REQUEST FOR INFORMATION ADDISON AIRPORT TUNNEL - PROJECT (DNT-260) 919

NO.	REVISION	BY	DATE
NORTH TEXAS TOLLWAY AUTHORITY ADDISON AIRPORT TUNNEL			
RFI# 919 - 927			
DRAWN	DATE	DESIGNED	DATE
CHECKED	DATE	SCALE	
CONTRACT NO. DNT-260 SHEET OF

No.	REVISION	BY	DATE
TEXAS TURNPIKE AUTHORITY ADDISON AIRPORT TUNNEL			
TUNNEL FIRE PROTECTION & PLUMBING PLAN			
HDR Engineering, Inc.			SECTION XIII
DRAWN: WTD	DATE: 12/05/96	DESIGNED: MLA	DATE: 08/28/96
CHECKED: BL	DATE: 08/28/96	SCALE: 1" = 50'	
CONTRACT No. DNT-260 SHEET P146 OF 166

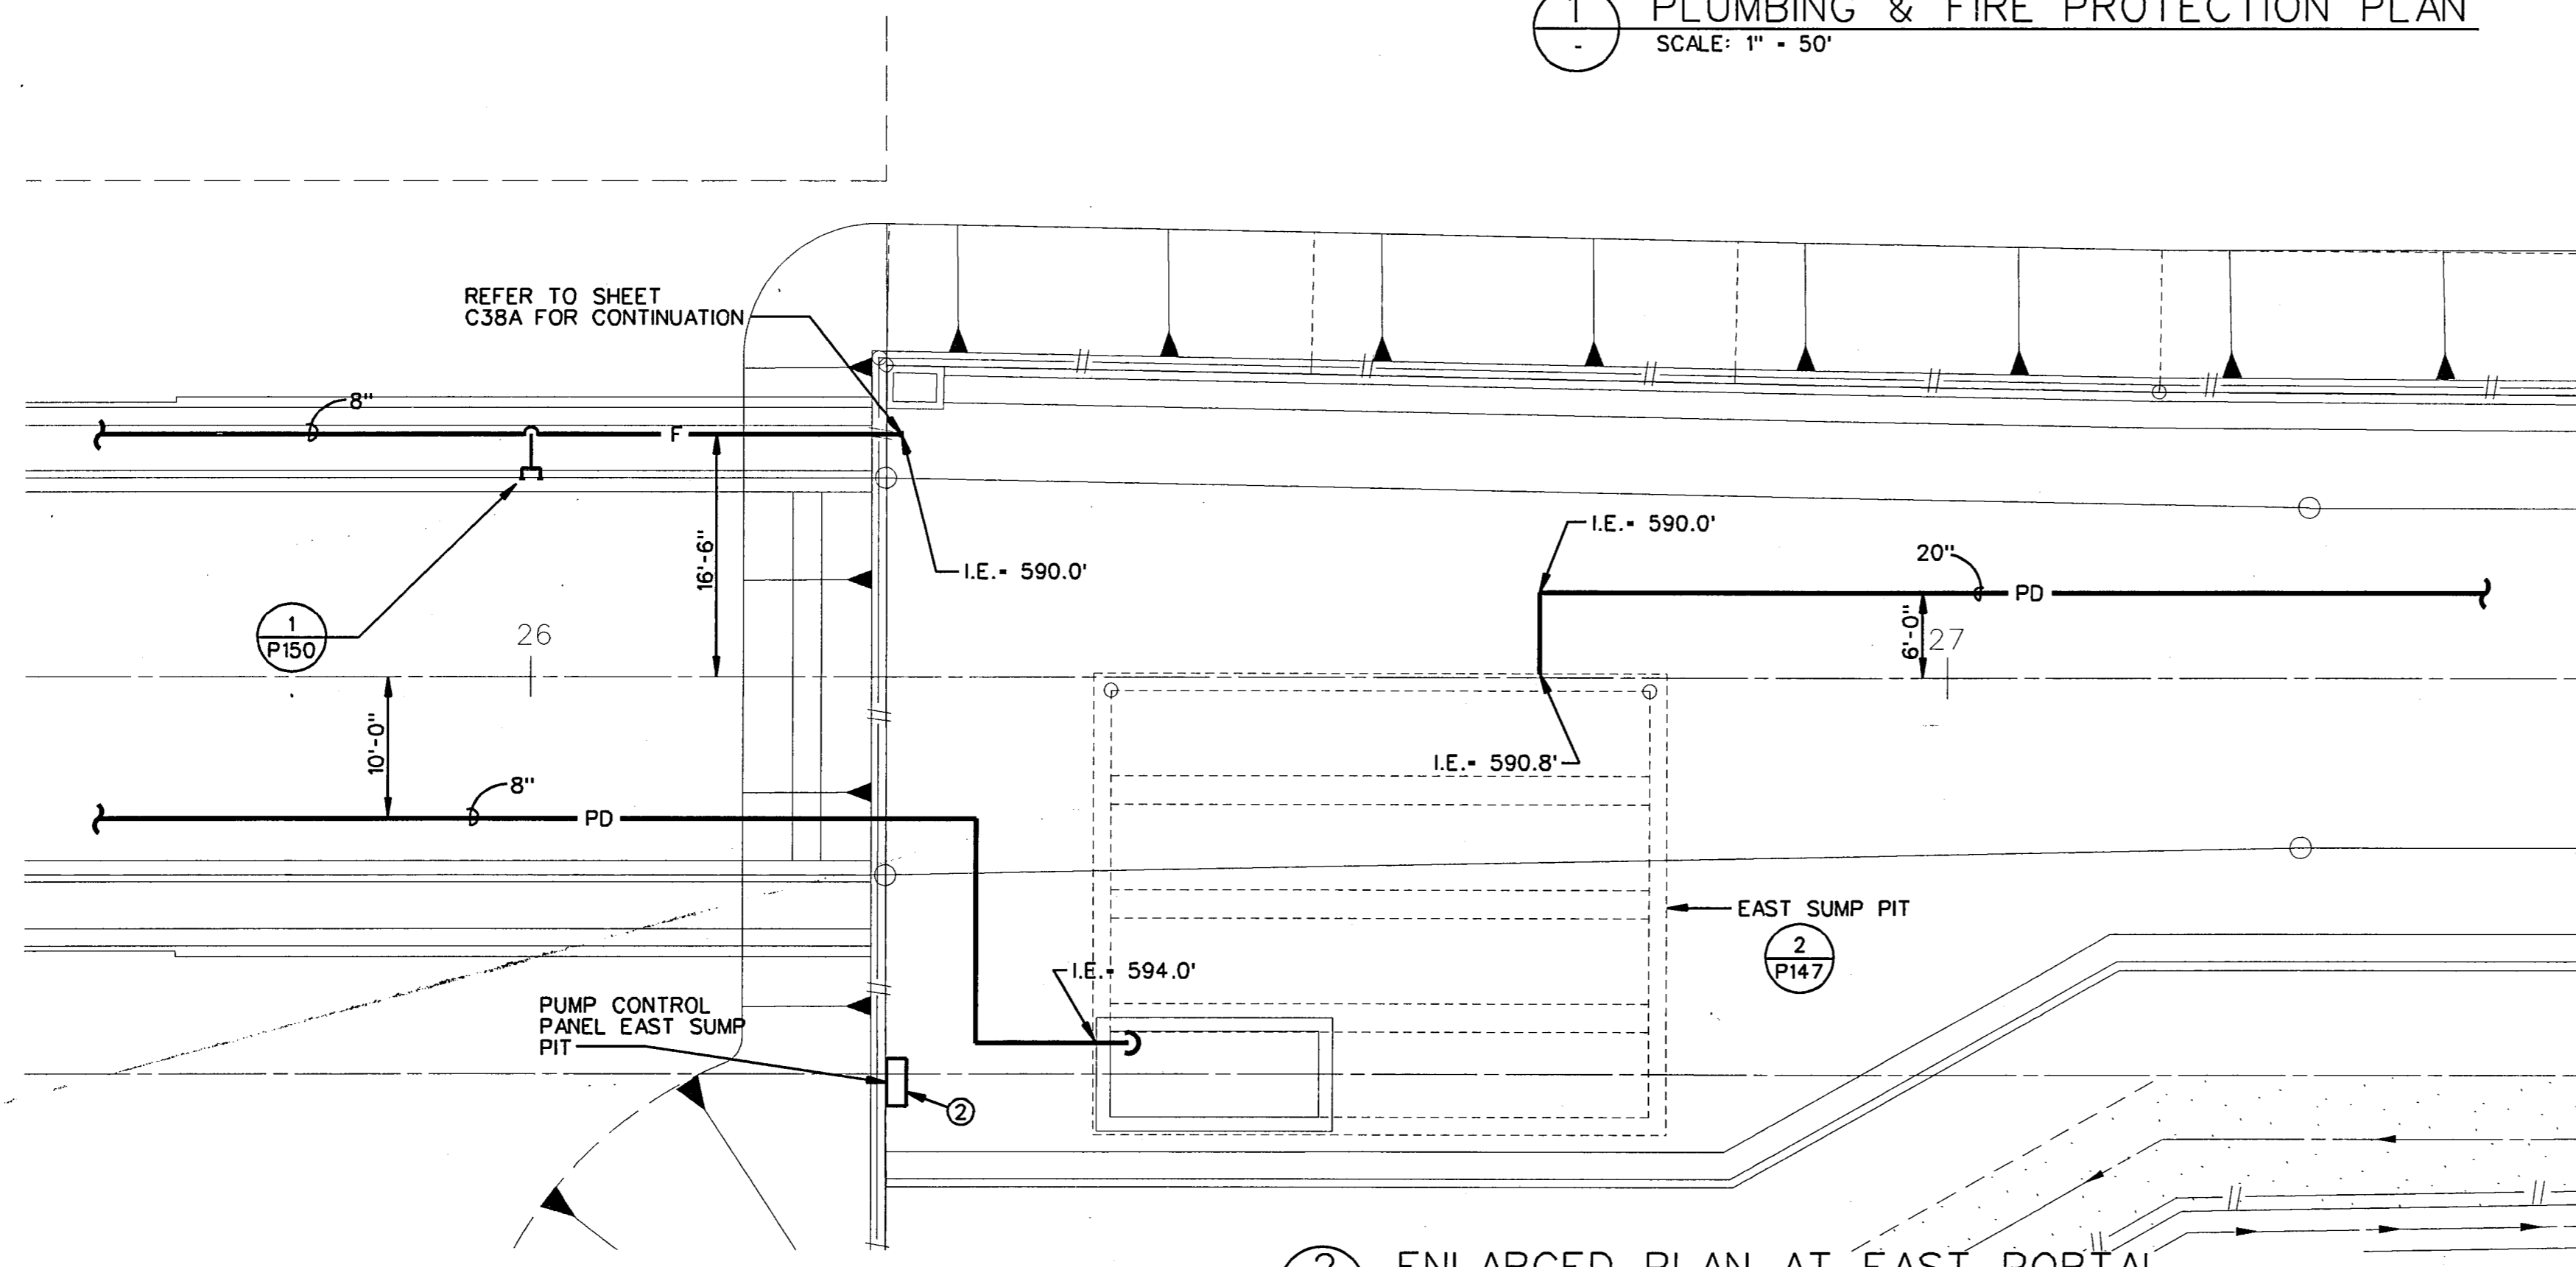
Problem: SHOULD THE BURN GATE VALVE SHOWN ON THIS CONTRACT DRAWINGS...

Response by Designer or other Organization: THE GATE VALVE IS IN THE MAIN DISCHARGE LINE FROM THE TUNNEL...
